DECISION DELEGATED TO DEVELOPMENT MANAGER

Application No:	H09-0234-20	Applicant:	ARB Commercial Enterprises Ltd
Proposal:	Change of use from veterinary surgery (D1) to two residential flats		
Location:	21-23 Boston Road South Holbeach Spalding		
Terminal Date:	31st July 2020

CONTRACT		SCALE	
Silverdale Veterinary Surgery		1:50.	
21 Boston Road		DATE	
Holbeach PE12 7LR.		February 2020	
TITLE		DRAWN	
		JK	
		CHECKED	
Proposed Ground Floor Plan.		DF	
		DRAWING NO.	
		19289_003 A	
		REVISION

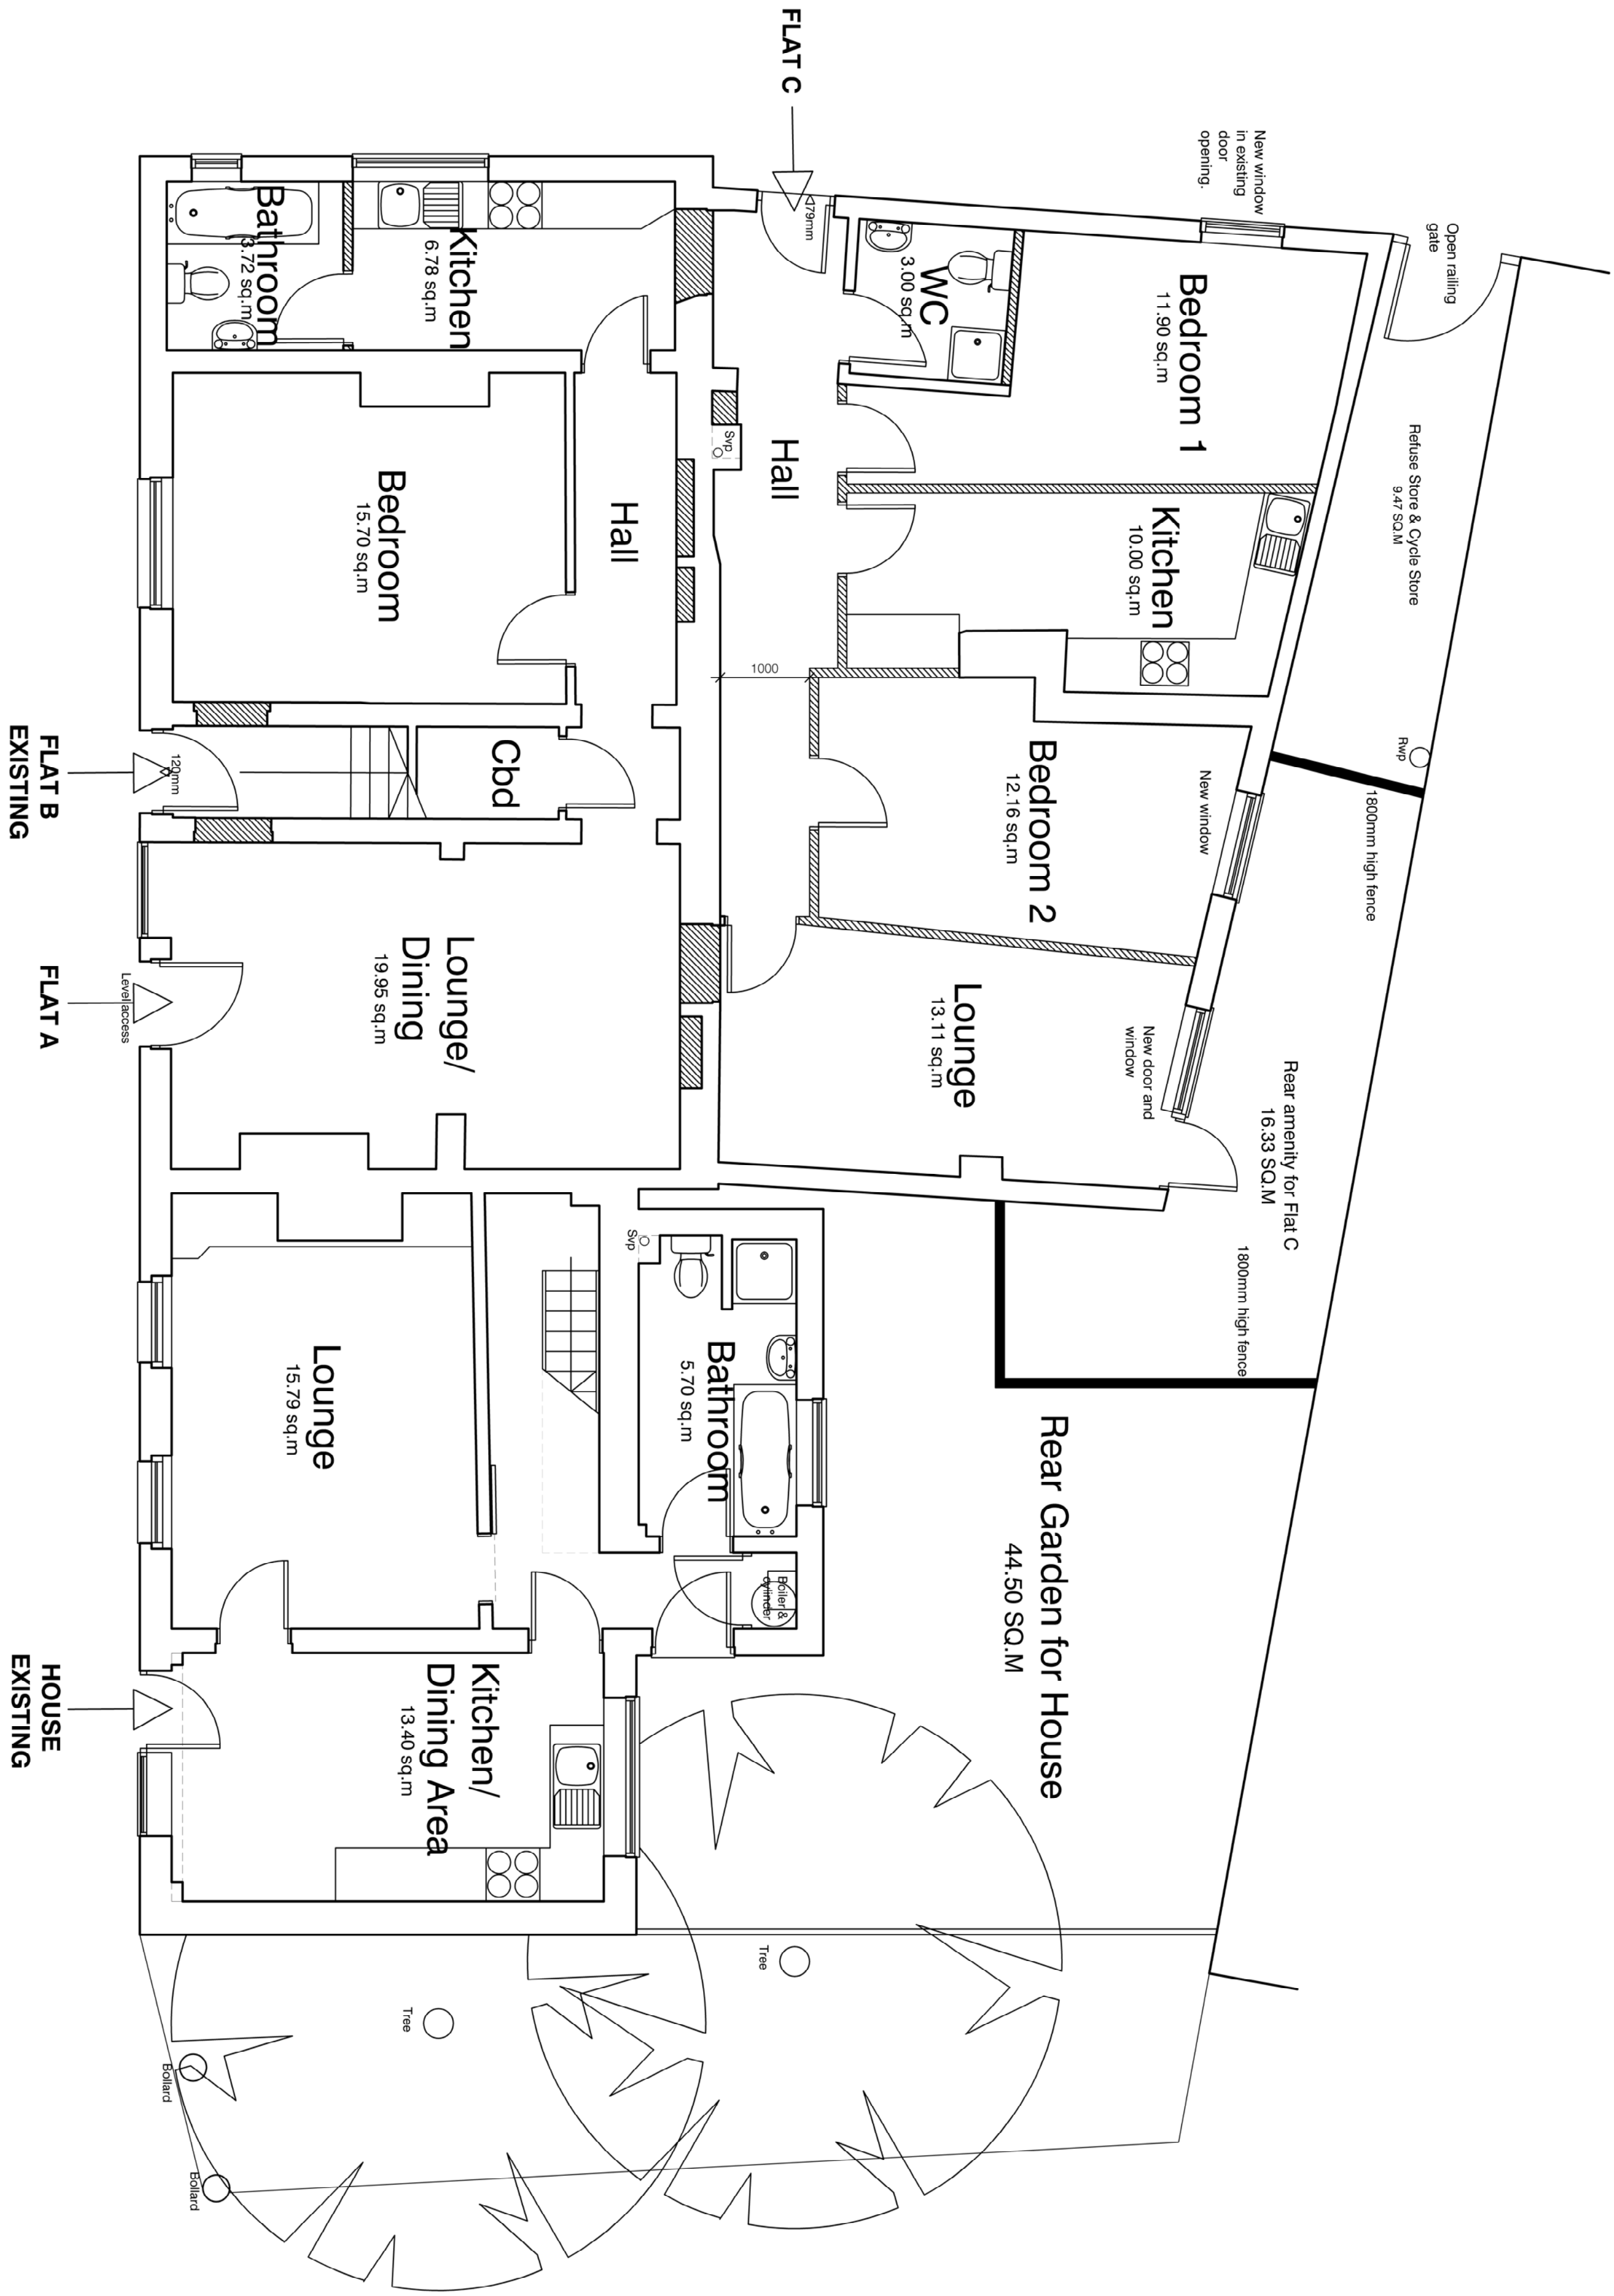
Objects to the plans on the grounds that 4 residential units would be too many, creating a HMO and that this would present waste storage problems due to there being no curtilage.

With regards to the layout of the proposal, the Local Planning Authority deems the proposed layout to be suitable for the creation of 2 additional modest flats.

The Local Planning authority recognises the comments of the Local Ward Member. However, this application is not for the creation of a HMO property, simply the creation of 2 additional, self-contained ground floor residential flats, in addition to the extant 1st floor self-contained flat and connected single, self contained dwelling. As all of the proposed residential units are self-contained, this cannot be considered to be a HMO application. Furthermore, the applicant has included provision for refuse storage in the rear courtyard of the property.

CONTRACT		SCALE	1:1250 & 1:500 @A3
Silverdale Veterinary Surgery		DATE	March 2020
21 Boston Road		DRAWN	JK
Holbeach PE12 7LR		CHECKED	DF
TITLE		DRAWING No	19289_005A
Block Plan & Site Plan		REVISION

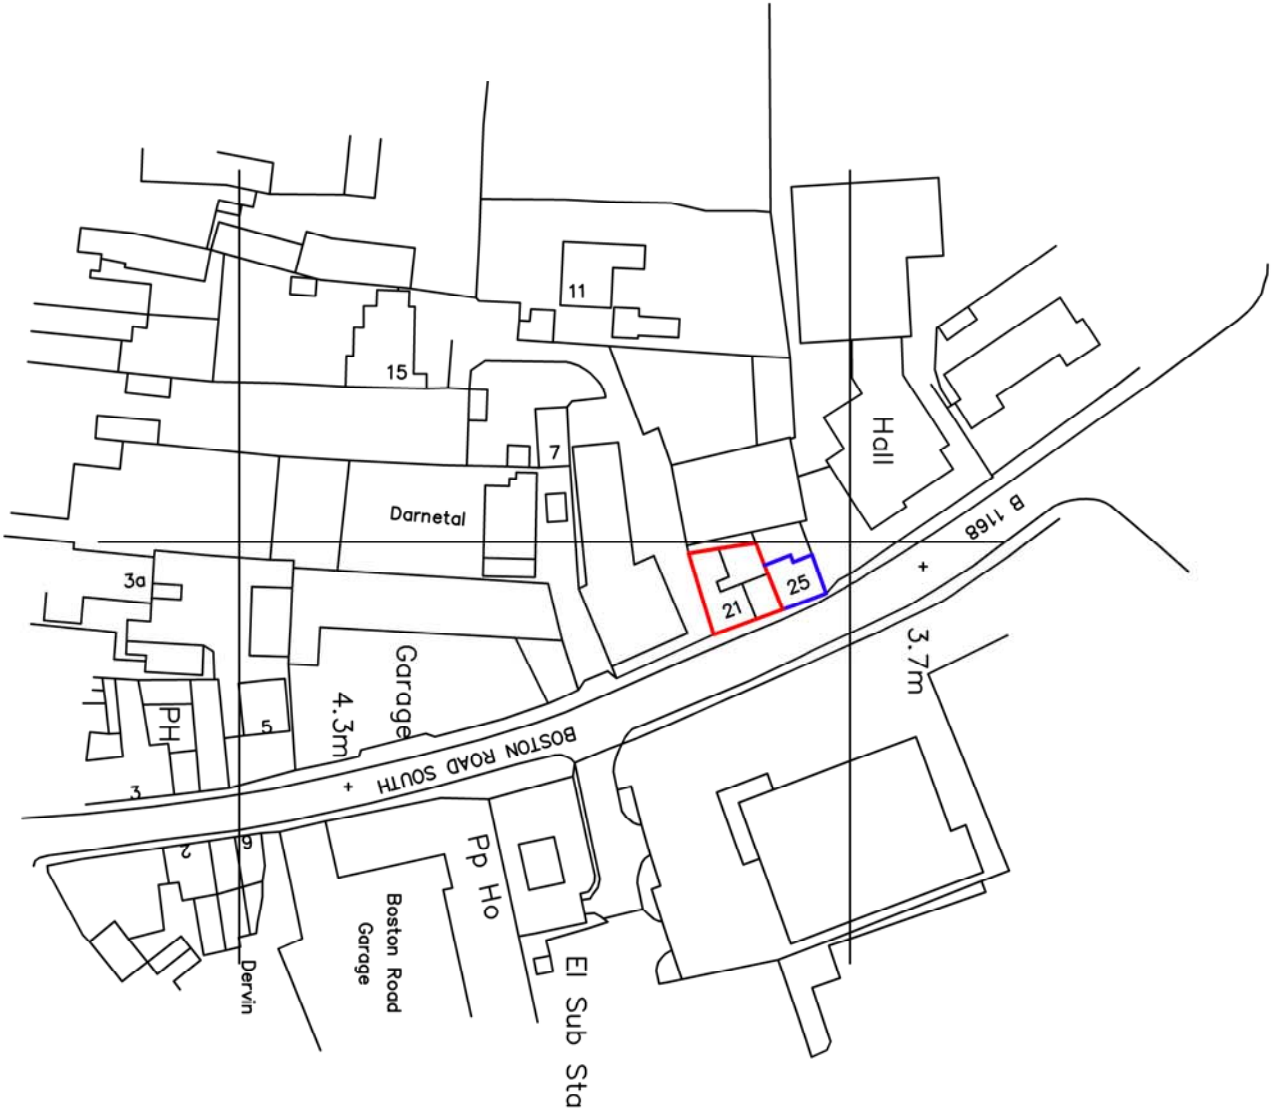
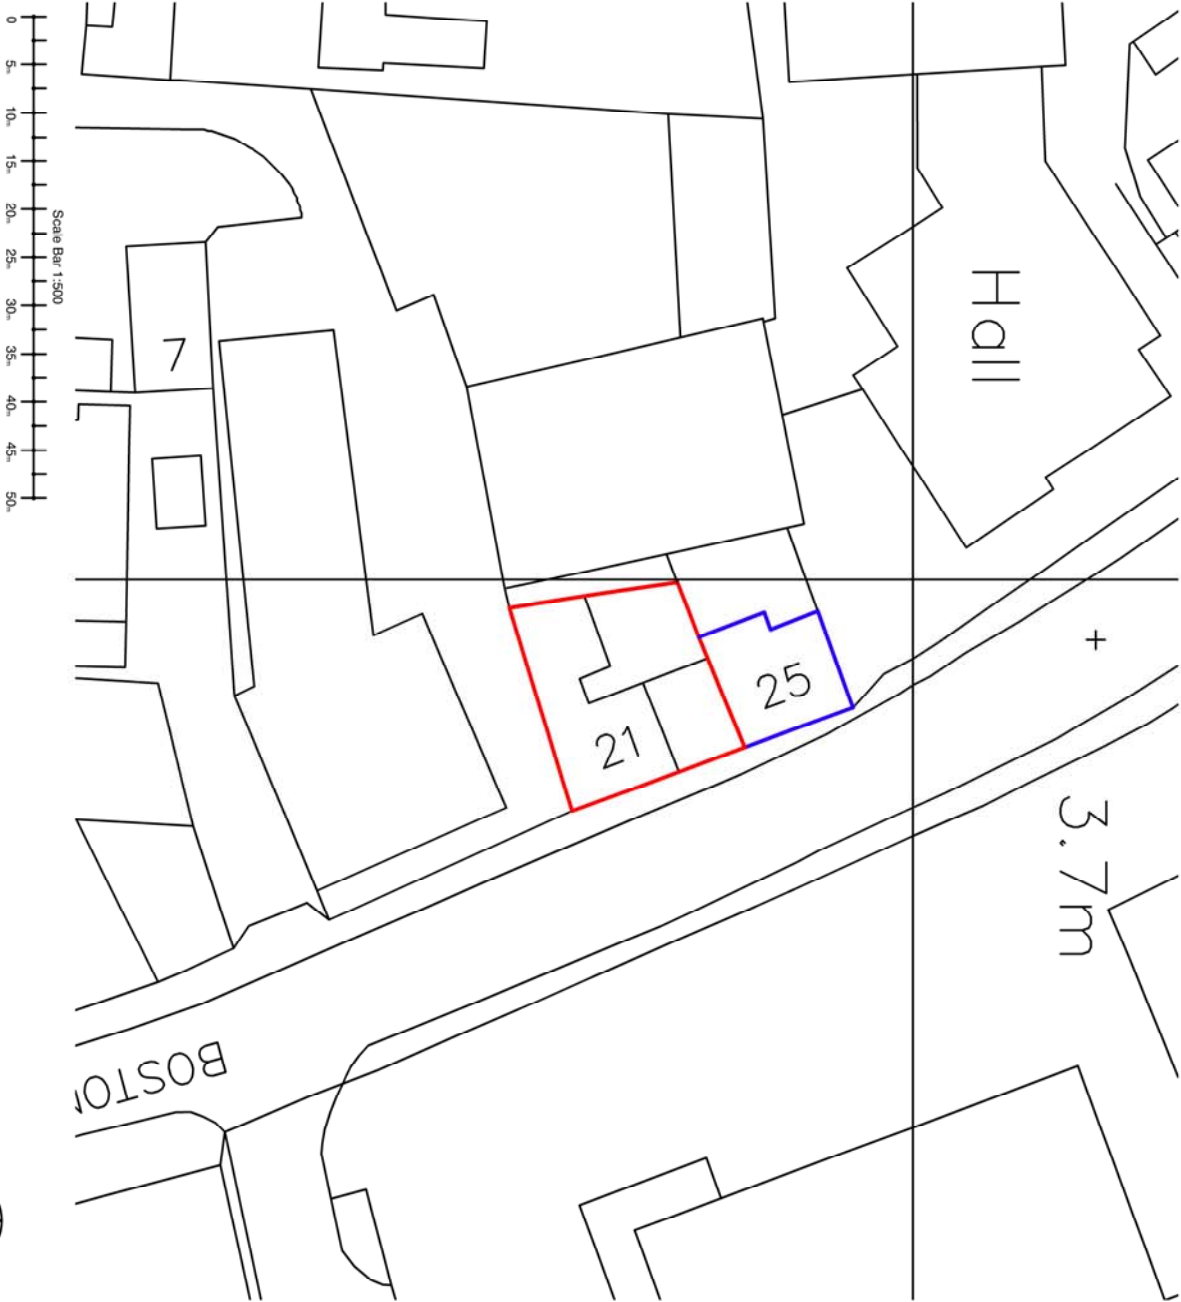
No objections but the applicant should be required to provide secure cycle storage on the site.

Then applicant was advised of this and has amended the application to include cycle storage facilities in the rear yard.

The application proposes the inclusion of a refuse storage area in the rear courtyard area of the property.

CONTRACT		SCALE	
Silverdale Veterinary Surgery		1:50.	
21 Boston Road		DATE	
Holbeach PE12 7LR.		April 2020.	
TITLE		DRAWN	
Existing & Proposed Elevation Plan.		JK	
		CHECKED	
		DF	
		DRAWING NO.	
		19289_006.	
		REVISION

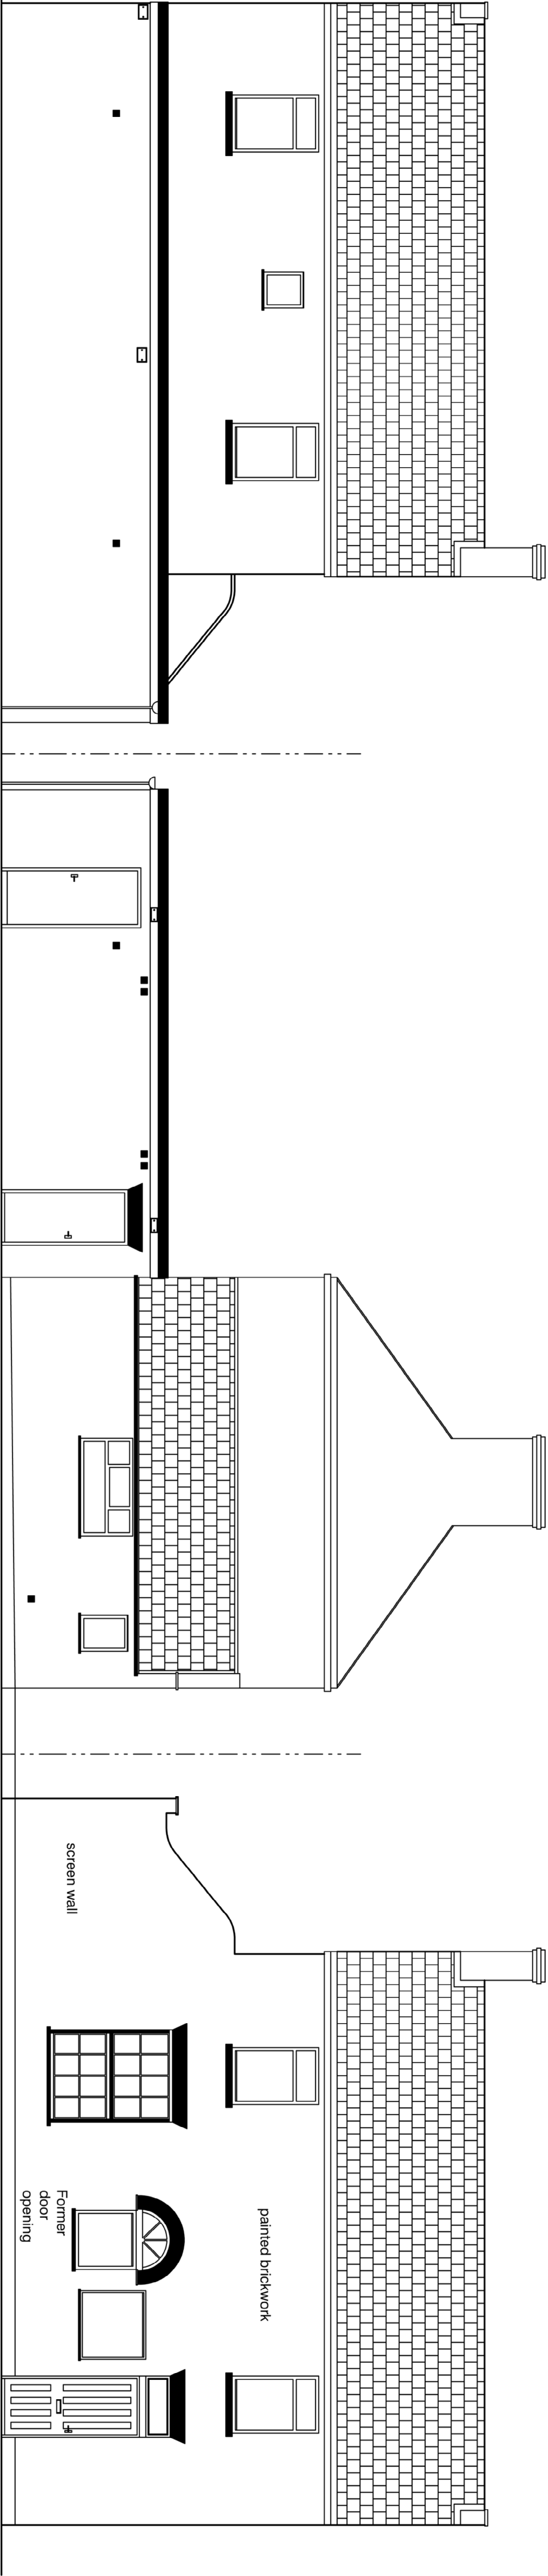
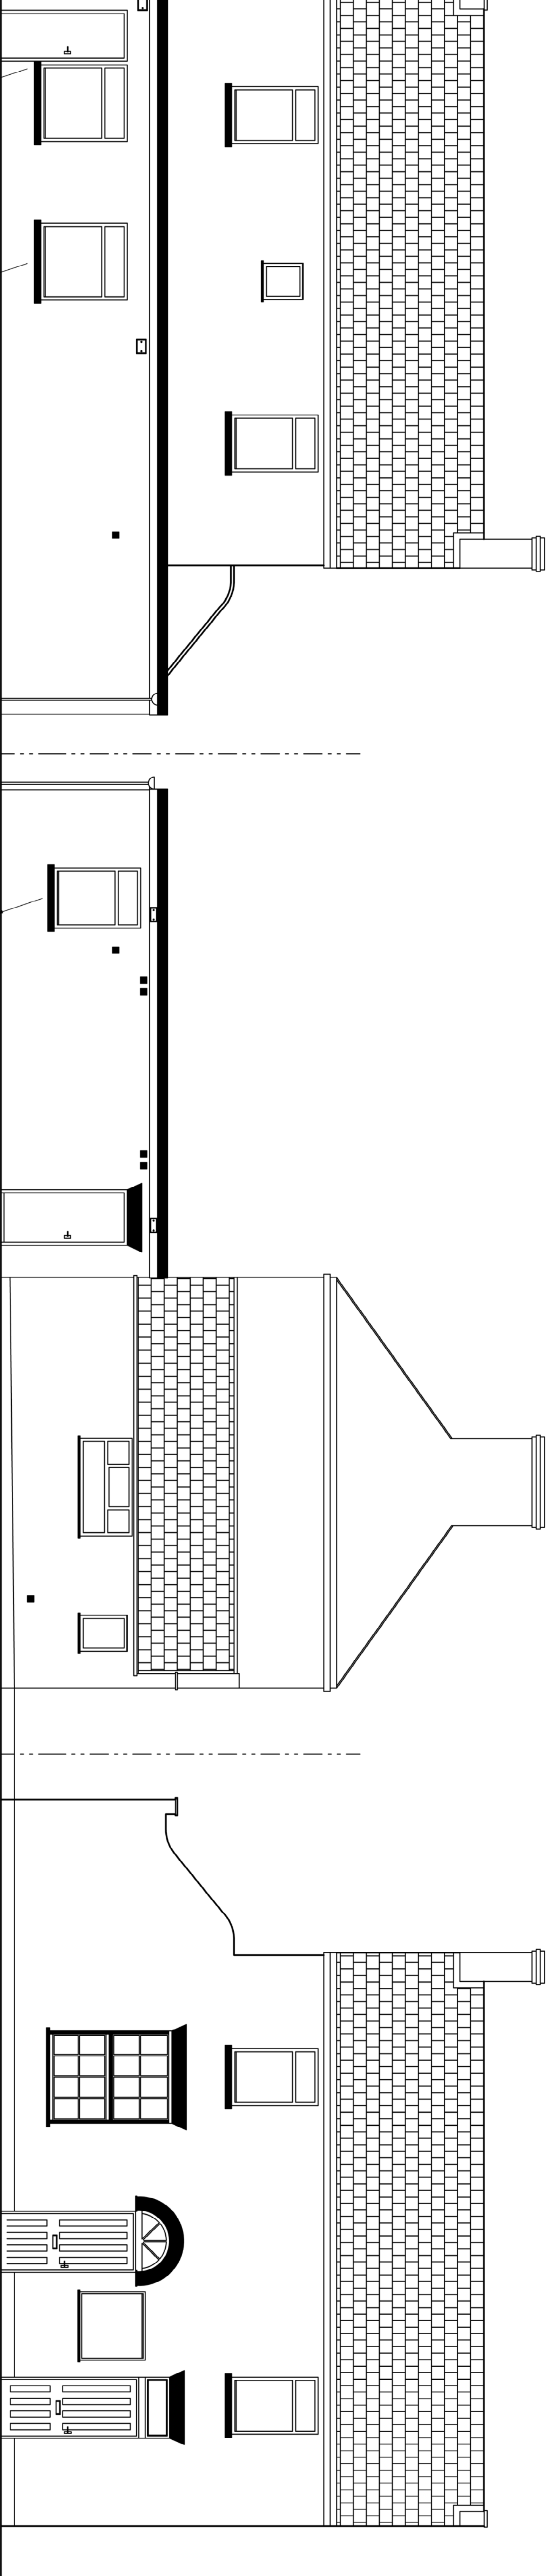
The visual changes to the property proposed by this application is for the replacement of a front, ground floor window with an additional access door to provide private access to one of the proposed flats, the creation of a new door and 2 new windows to the rear elevation and the replacement of a door with a window on the side (southern) elevation.

The Local Planning Authority does not believe that there is any risk presented to the value or significance of any designated heritage asset. This is because there are no individual designated assets within the visual context of this property, and the visual changes to the building (installation of new ground floor doors and windows) are as minor as to have no appreciable negative impact upon the qualities of this area of the conservation area. Furthermore, this application proposes to bring back into use the ground floor of this property which has now been empty for some time. Bringing a property in a prominent conservation area location back into regular use will prevent it from entering a state of disrepair and becoming a draw on the qualities of the area. For this reason, it must be considered that this application helps to Enhance the historic environment in accordance with section 16 of the National Planning Policy Framework (2019).

The Local Planning Authority does not seek any amendment to the design or layout of the proposal. As outlined above, the only design change to this property is for the installation of a new ground floor doors and windows. For the reasons listed in the above 'Heritage Impact' section, this design is deemed to be appropriate.
